**REQUEST**

Current Zoning: RE-1 (research district)  
Proposed Zoning: UR-2(CD) (urban residential, conditional)

Approximately 6.94 acres located at the northwest corner of William Ficklen Drive and Ben Craig Drive, west of Mallard Creek Road and east of WT Harris Blvd.

The petition proposes development of a vacant site in the University Research Park area for up to 82 single-family attached townhomes.

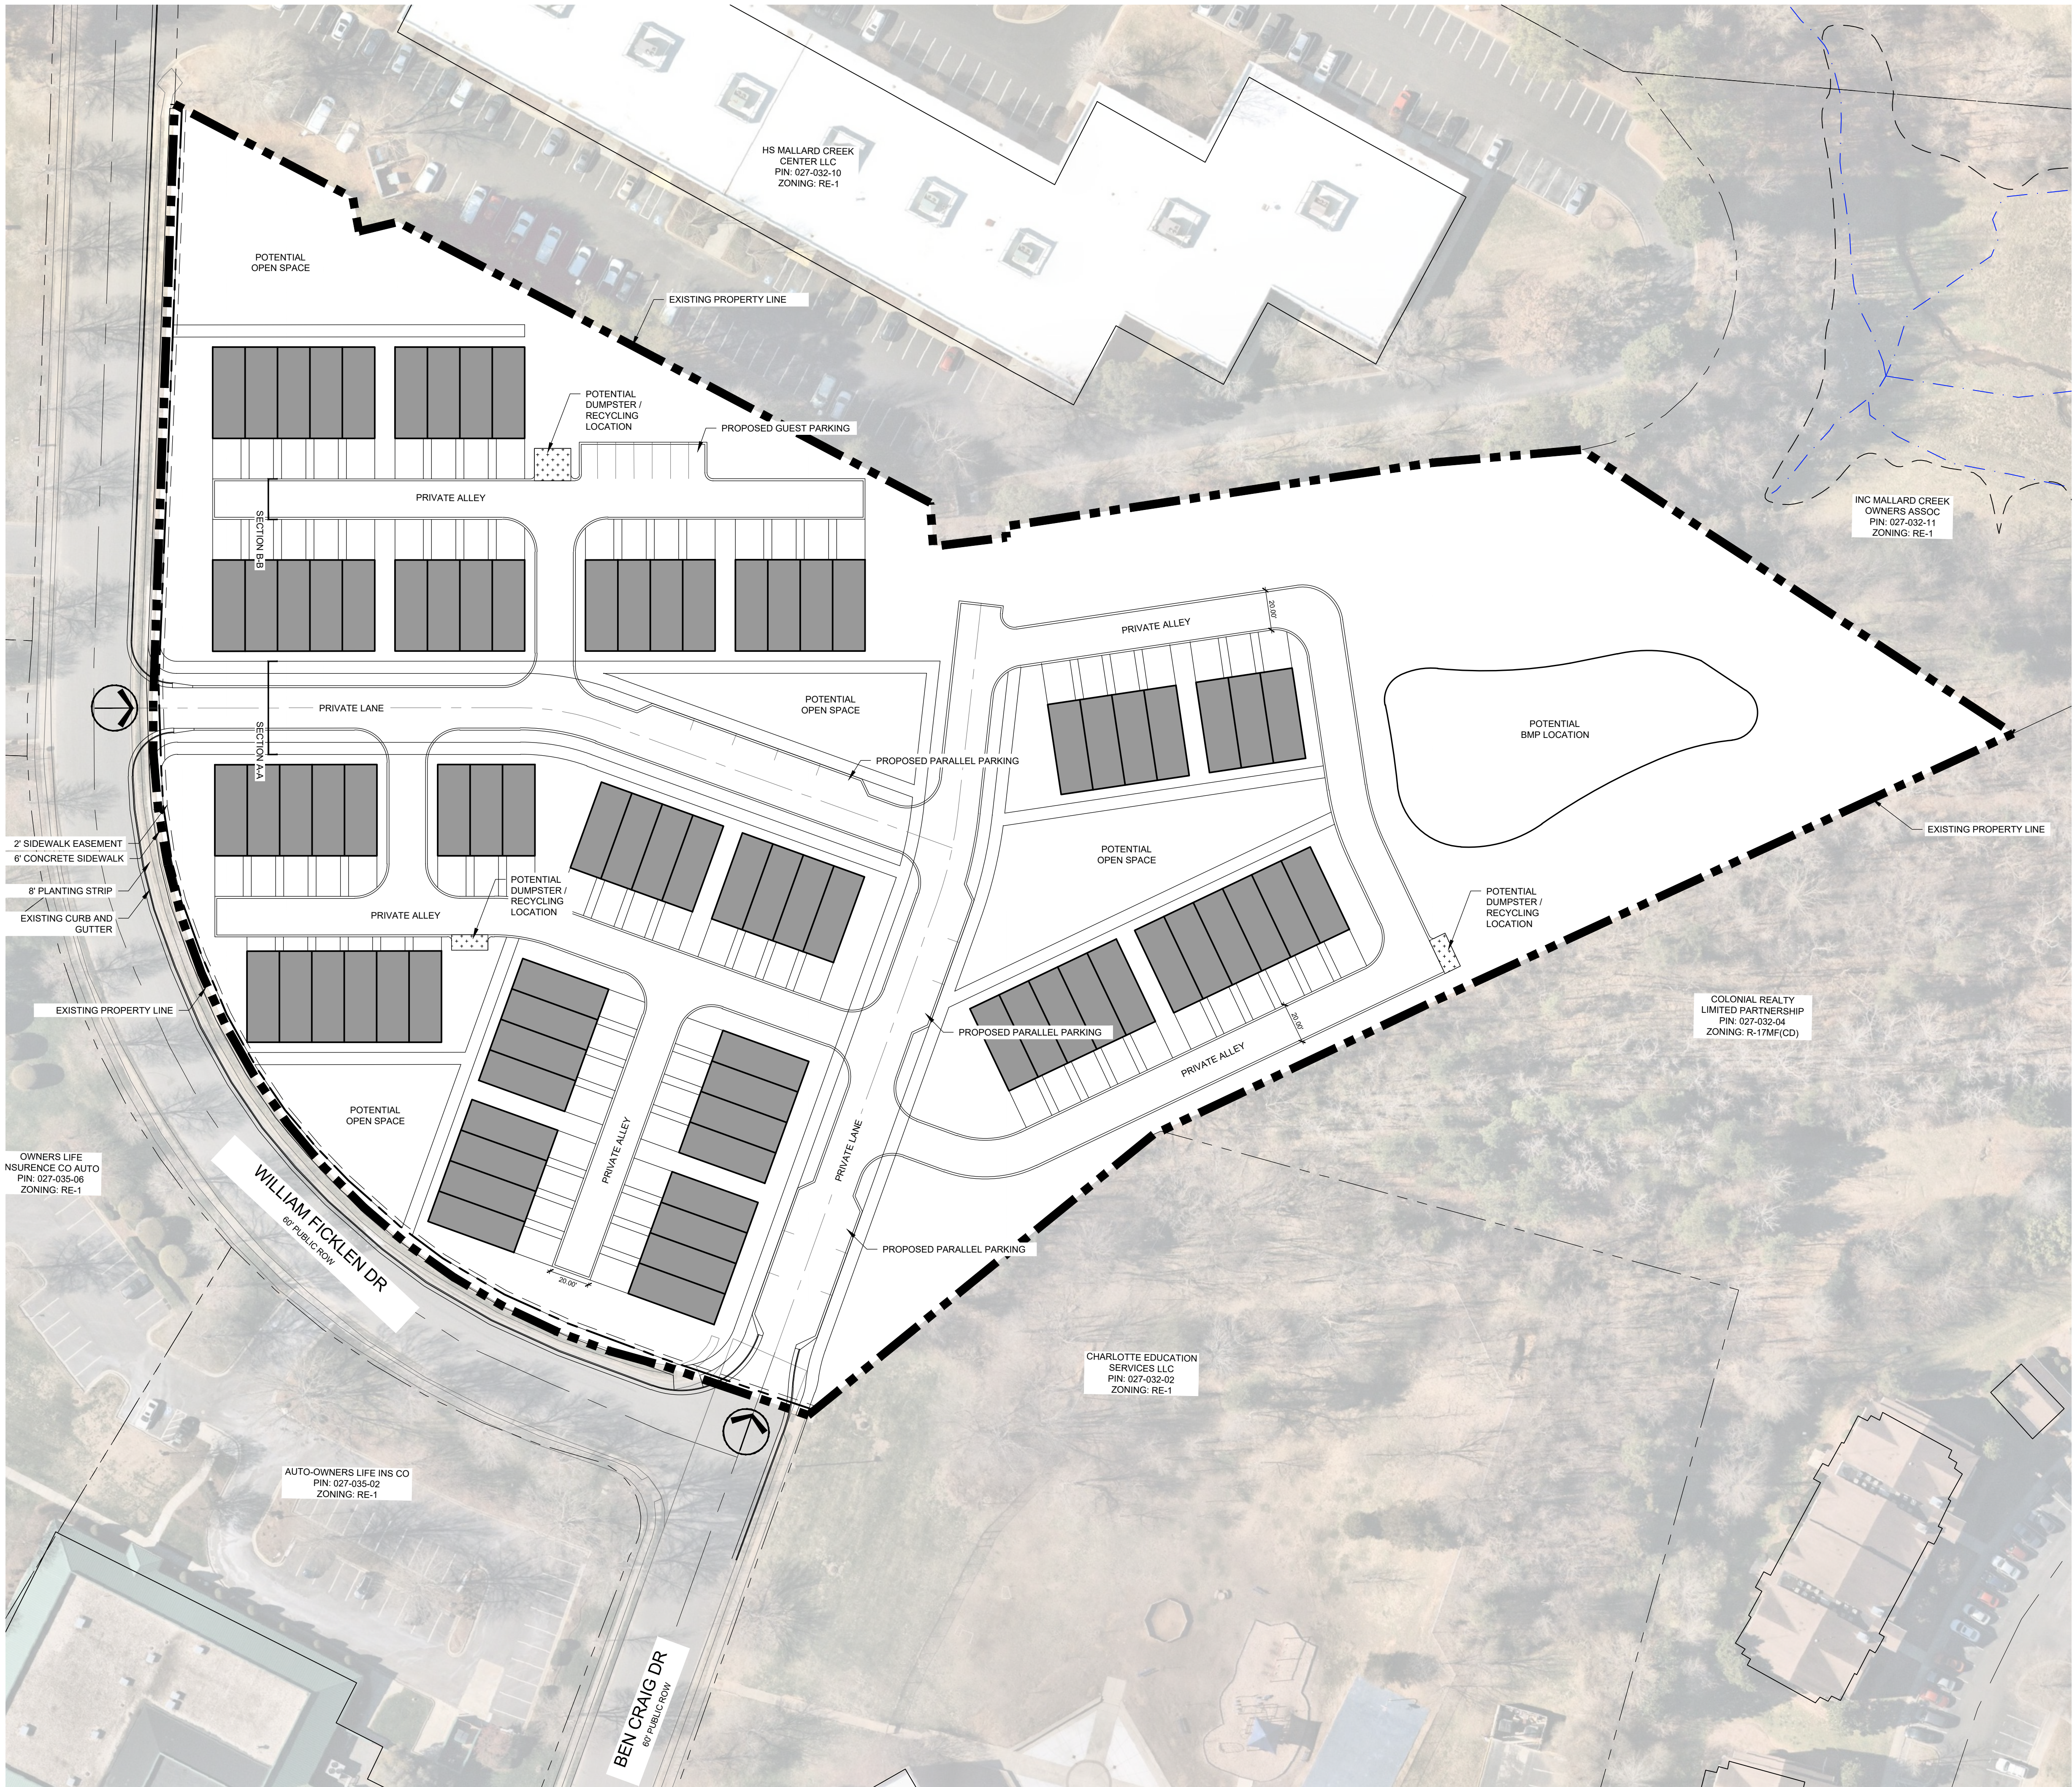
4. ~~Revise site plan to show proper separation between the proposed on-street parking and the intersection. A minimum of 20 feet is required from the curb return to the parking stall.~~ **Addressed**

- Site and Building Design
6. ~~Provide an 8 foot sidewalk and an 8 foot planting strip along frontage of William Ficklen Drive.~~ **Addressed**
